Our Reference: SYD20/00773/10

Departments Reference: SSD-10479

**EXHIBITION OF EIS – AMMENDED PLANS & DOCUMENTATION – (106-228) 200
ALDINGTON ROAD INDUSTRIAL ESTATE - KEMPS CREEK**

Attachment A

**Figure 16: Interim 2026 SIDRA Intersection Layout**

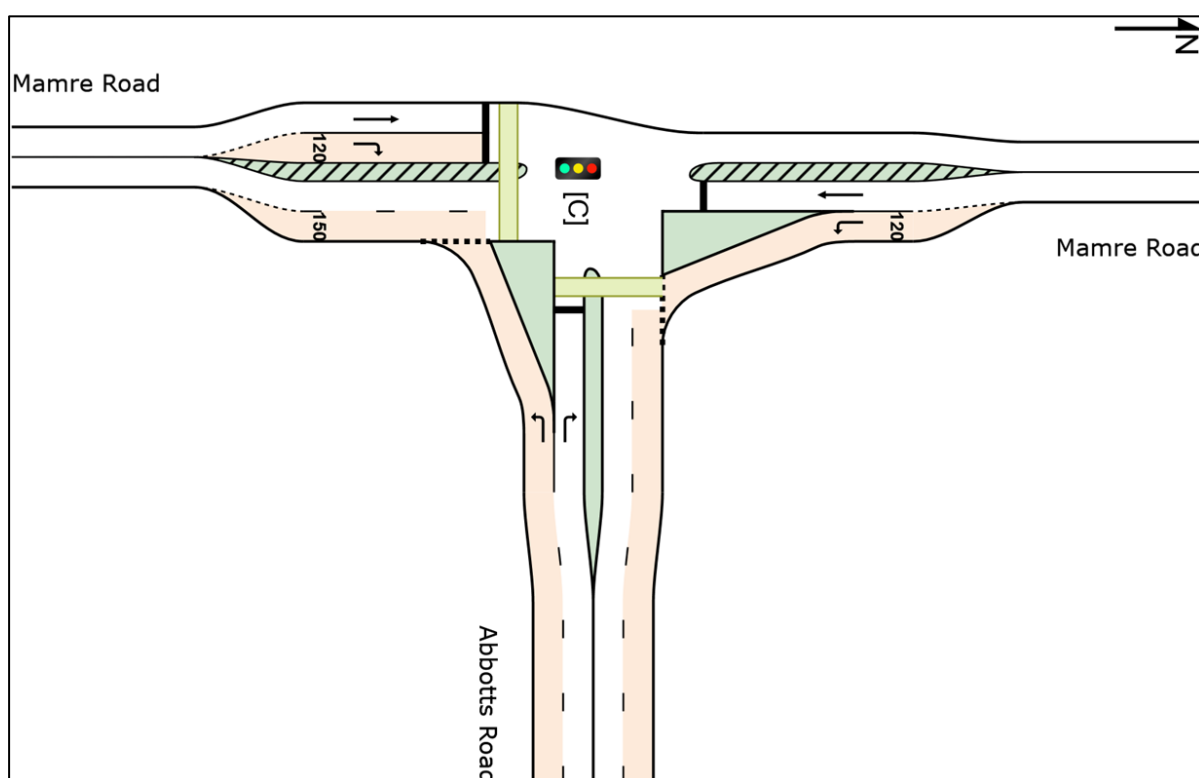
- a. The SIDRA model used optimum cycle times of between 90 – 120 secs. In order to determine the worst case scenario the intersection should be modelled at a cycle time of 120-140 secs and no less. TfNSW suggests that different phasing options are investigated with the 120+sec cycle time to assist with managing queue lengths.

- b. There are some anomalies in the SIDRA outputs. It is unclear why the 3% growth rate has not been included on all legs. The base model for 2026, 2031 and 2036 does not change for the traffic entering and exiting Abbots Road.

- c. The report mentions that the 2036 model does not include the SLR. It is unclear why there is a reduction in vehicle movements entering and exiting Abbots Road for the 2036 outputs. Further clarity is required to understand the reduction.

- e. Appendix A2 - 2031 AM Project Case – the SIDRA outputs indicate that the 95% back of queue is at 127.3m for the Mamre Road (south) right turn movement, which will queue out into through lane. This indicates that the right turn bay will not adequately support the proposed traffic specified in the Masterplan.

- a. Appendix A1 - 2026 PM MRP LOG – the right turn movement from Mamre Road is operating at LOS E. The 95% back of queue is showing to be at 97m, whereas the right turn bay only has 100m storage. This results in a risk of traffic queuing out into through lane. Therefore should further investigations be undertaken which take into account the MRP LOG the intersection design would need to ensure that the additional traffic can be accommodated for.
- b. Appendix Z - Civil Drawings - Intersection (1) & (2) – Turning path plans are provided for 30m PBS type 2B. According to the Draft Mamre Road Precinct DCP Road design item (16), it should be tested for 36.5m PBS Level 3 type A vehicles.

TfNSW believes that there is a need for further refinement and clarification to determine the scope of the intersection. The modelling indicates that a critical leg is at risk of not being able to accommodate for the traffic proposed under this proposal in isolation in 2031. Whilst it is understood that there are constraints in the road reserve at this location, there is still a need to ensure that the intersection can

operate at a safe level. The length of the right turn bay on Mamre Road (south) needs to be lengthened to accommodate for the proposed traffic.

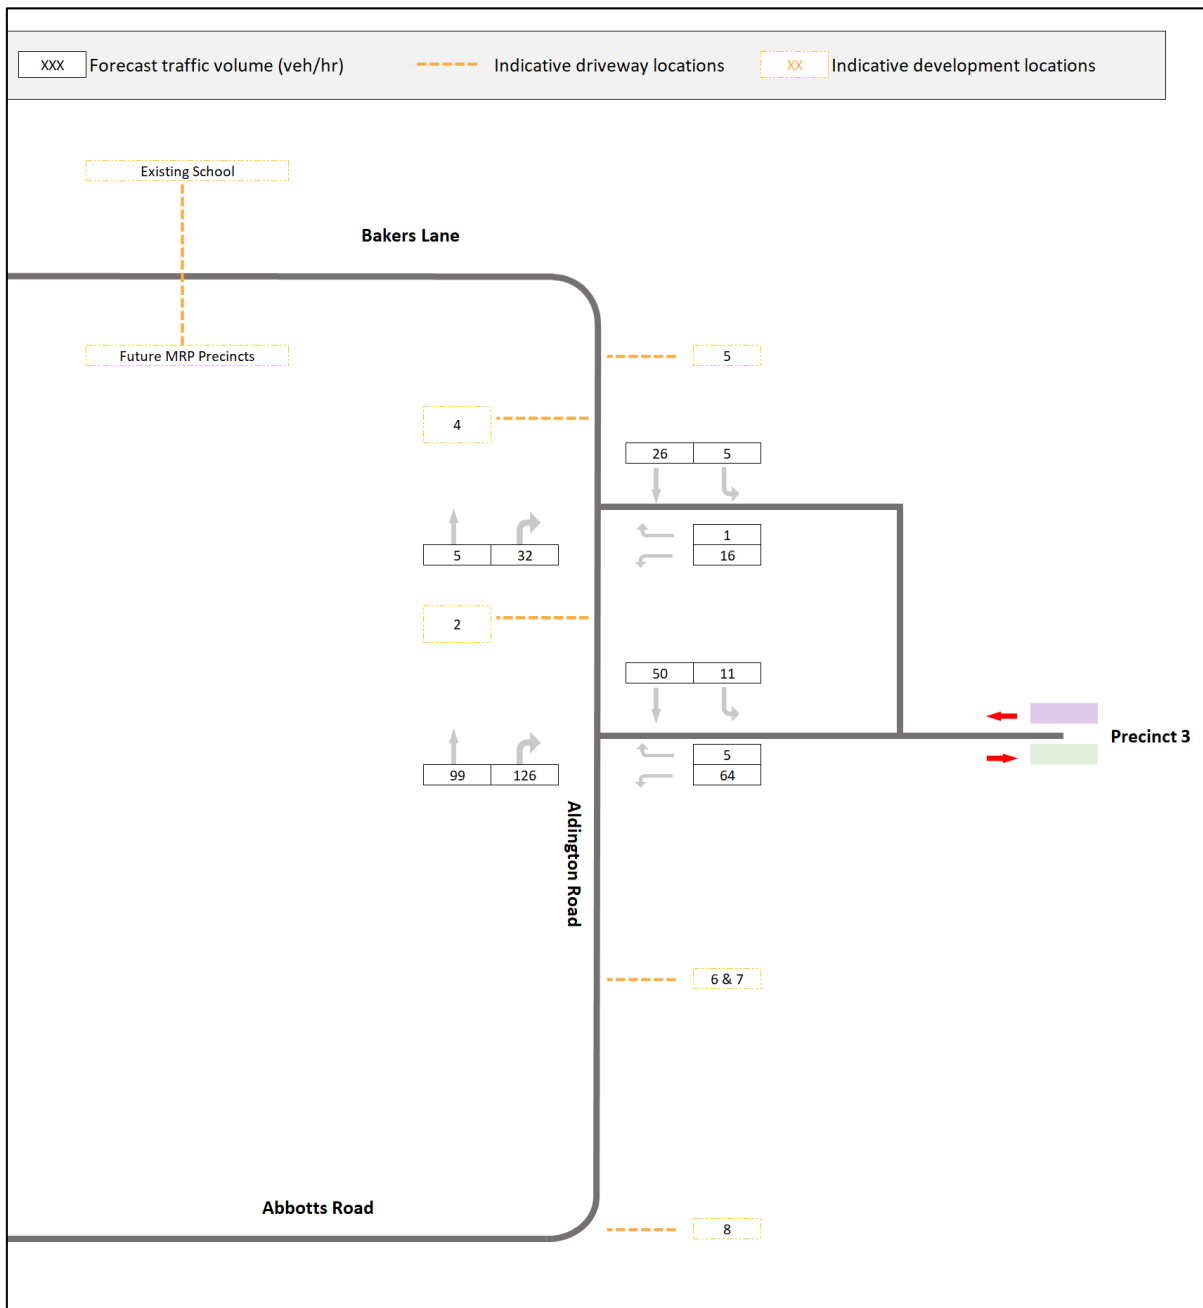
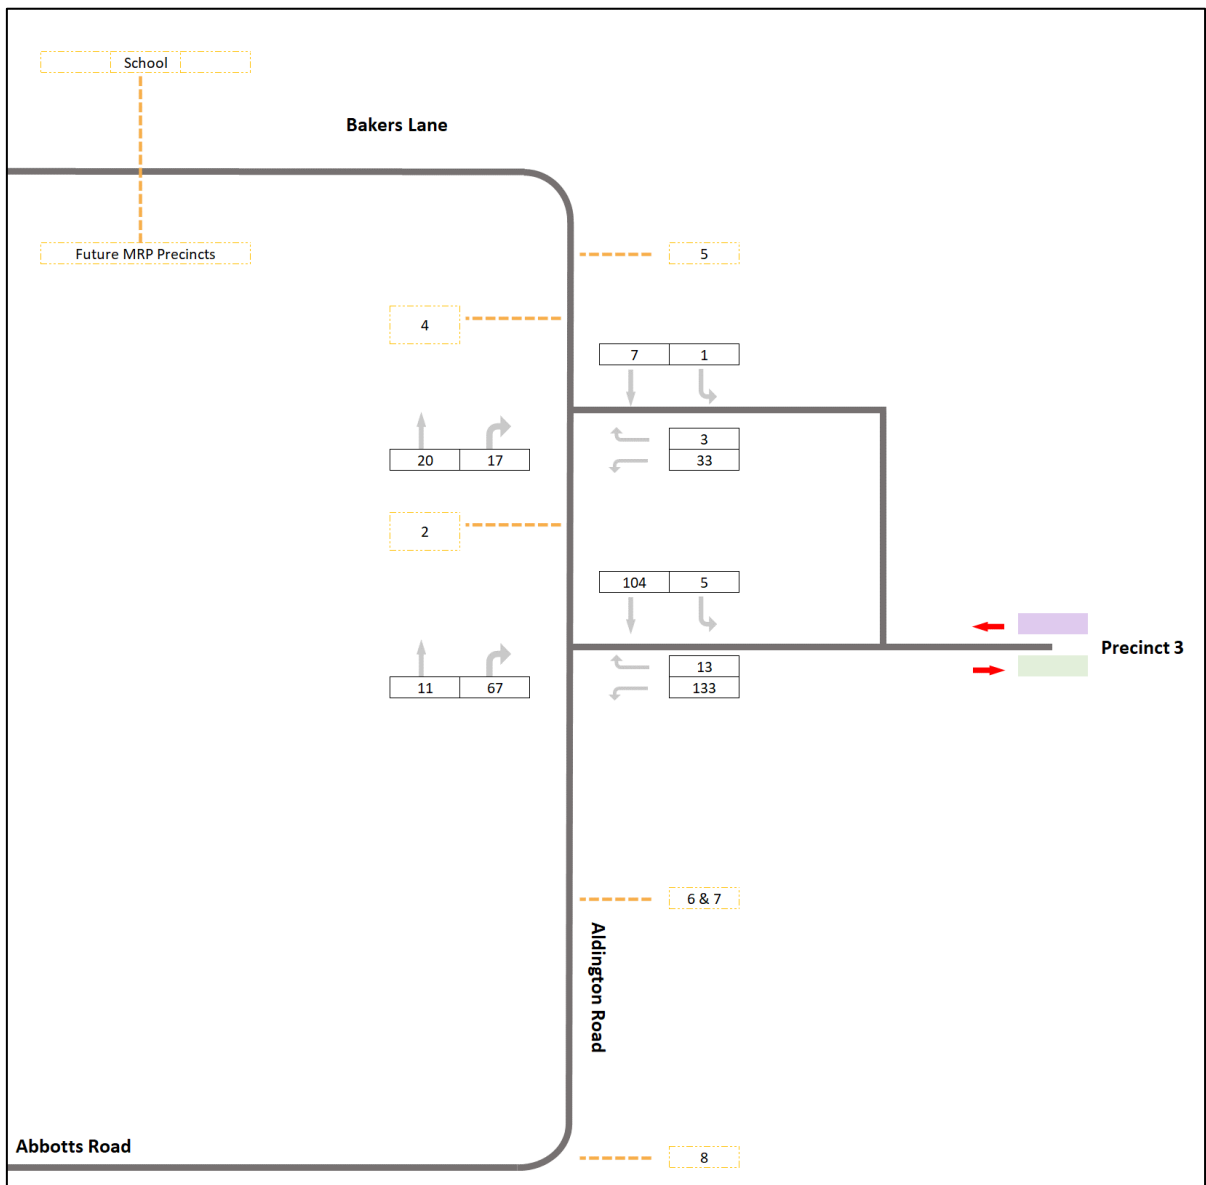
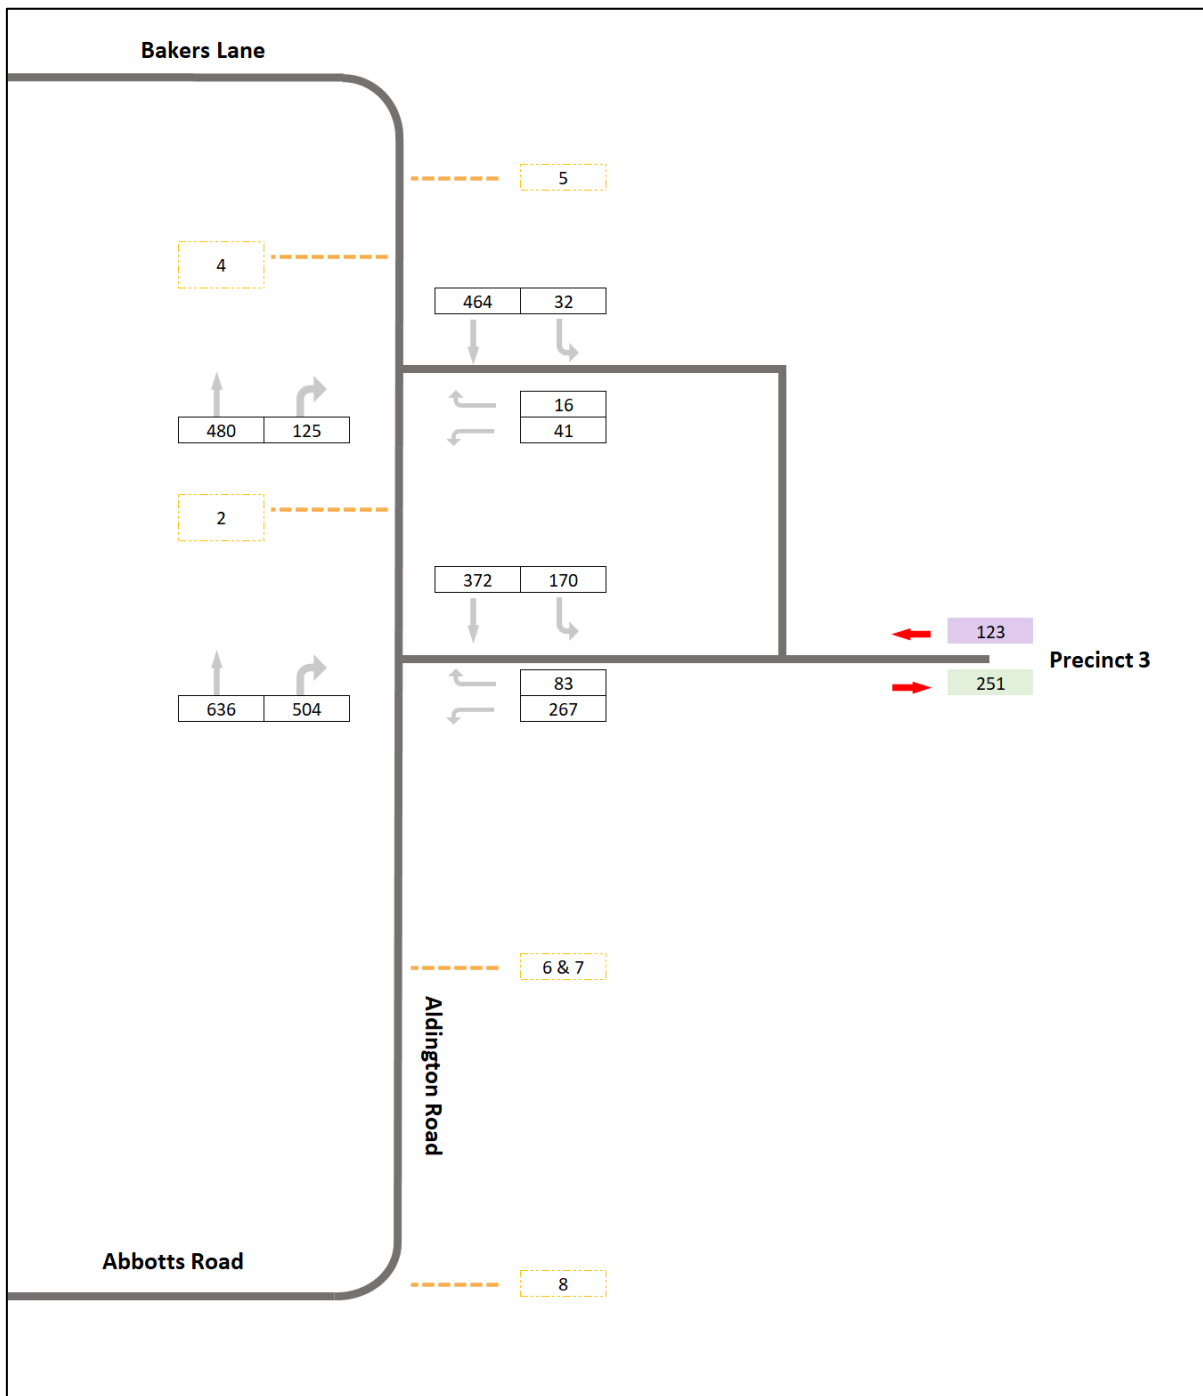
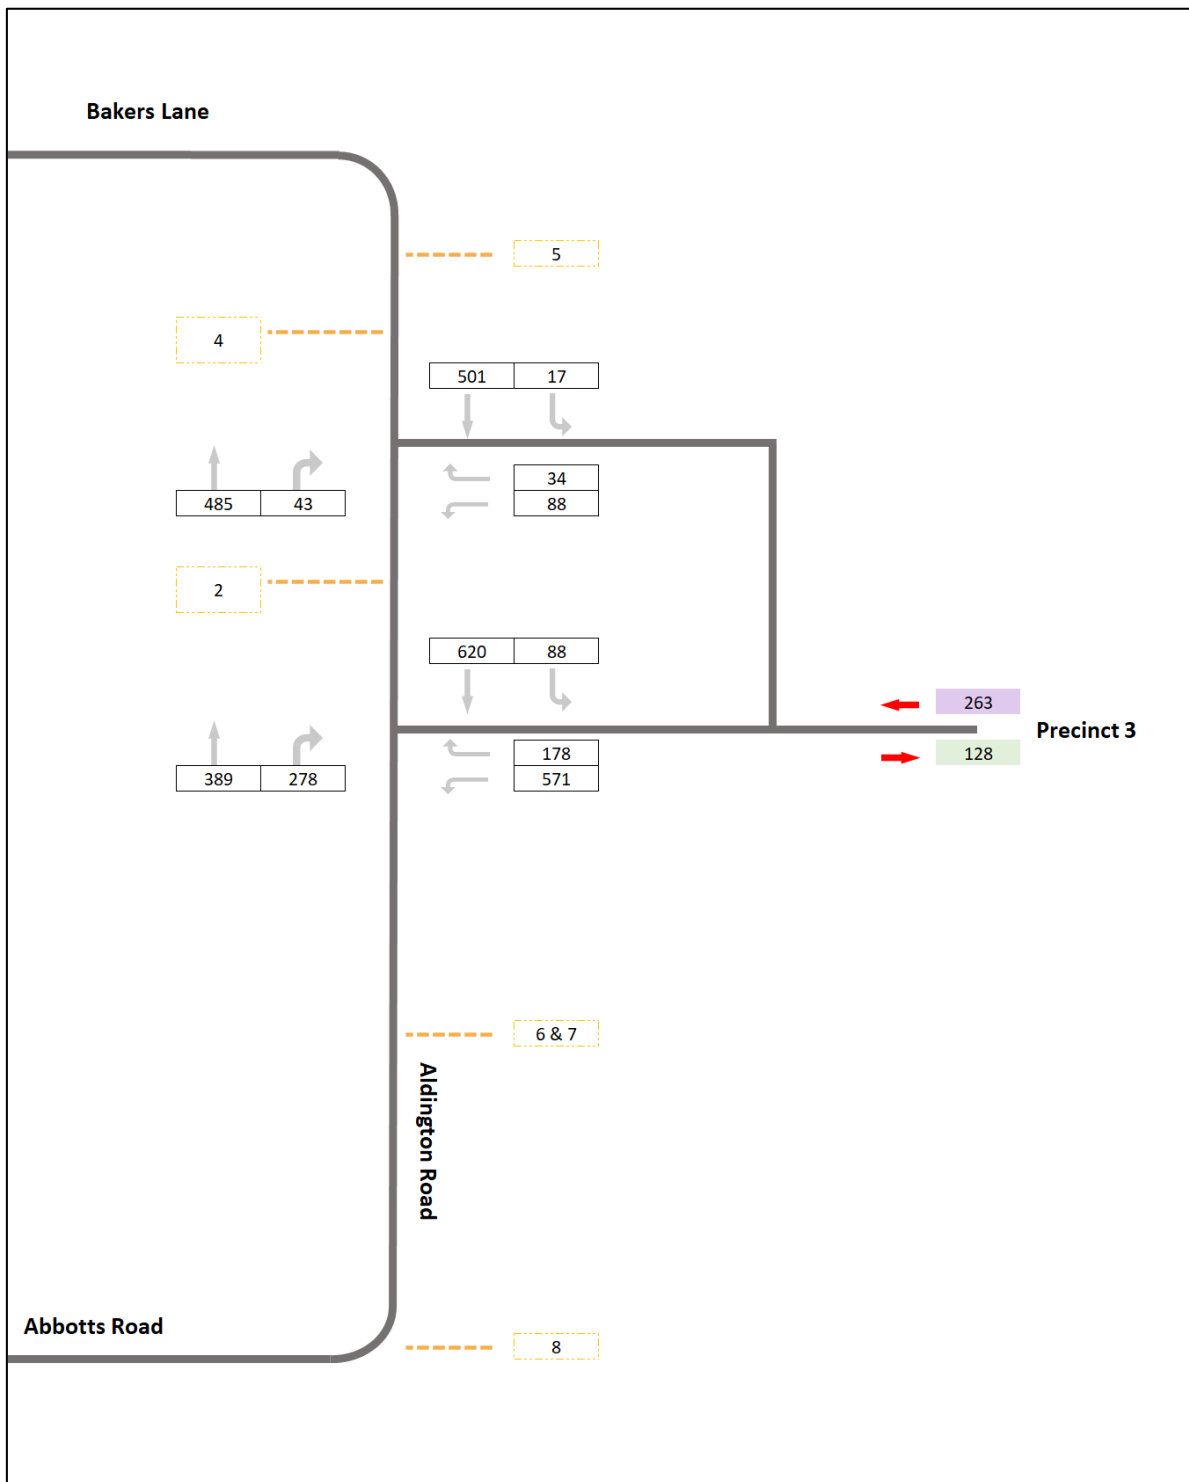
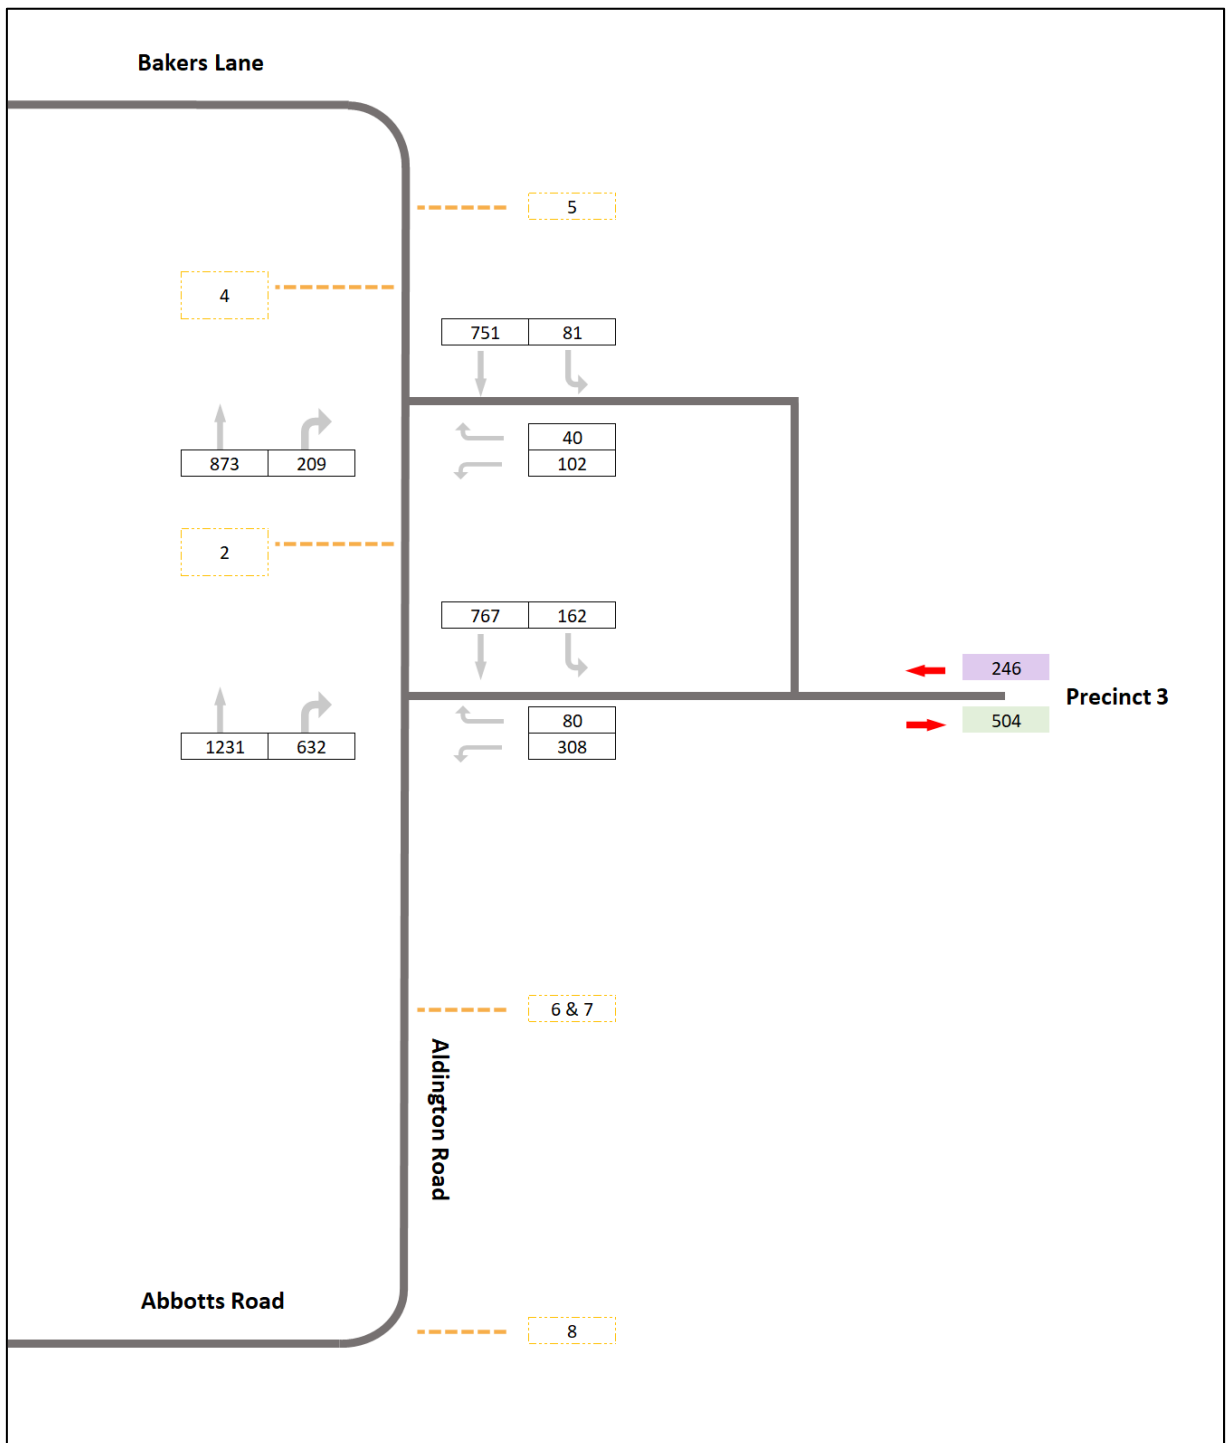
- d. A traffic assignment diagram should be provided showing what percentage of vehicle movements is proposed to travel north or south on Aldington Road. In addition further clarity is needed to ensure that the model provided directs all heavy vehicle movements to access Mamre Road from Abbots Road intersection and not Bakers Lane. This is due to the presence of schools along Bakers Lane.
